# Durham County Council

Application for a non-material amendment following a grant of planning permission.

DOUBLE GARAGE TO SIDE OF BUNGALOW.

DM/22/00415/FPA

Front - 16ft 6in

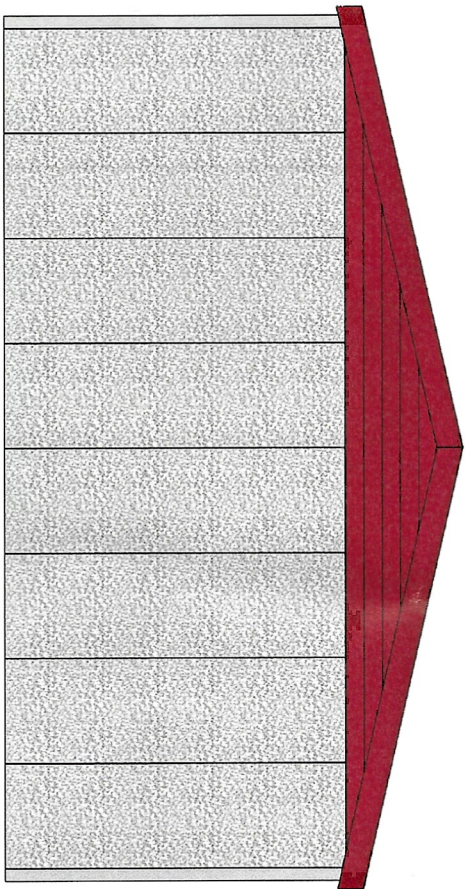
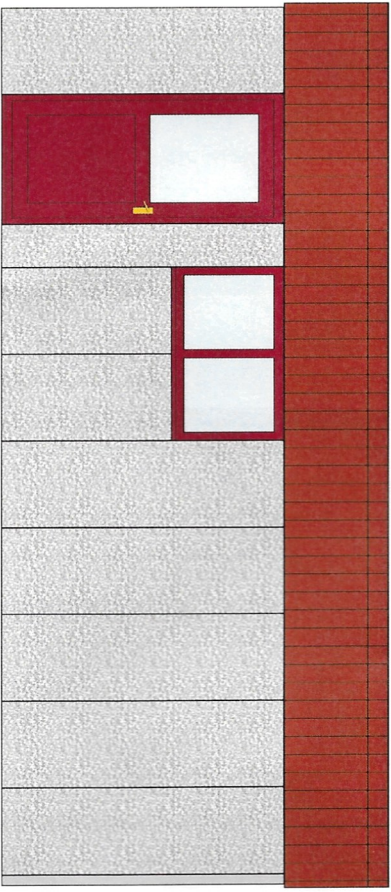
WE NEED TO CHANGE THE TWO GARAGE DOORS TO ONE LARGE SINGLE.

THE INTERNAL WIDTH OF THE FINAL PLANS OF THE GARAGE WERE FOUR INCHES SMALLER, THIS BEING THE CASE THE CAR WOULD NOT FIT. SO ON CONTACTING THE GARAGE PROVIDER THERE ONLY ANSWER WOULD BE TO FIT ONE LARGE SINGLE DOOR.
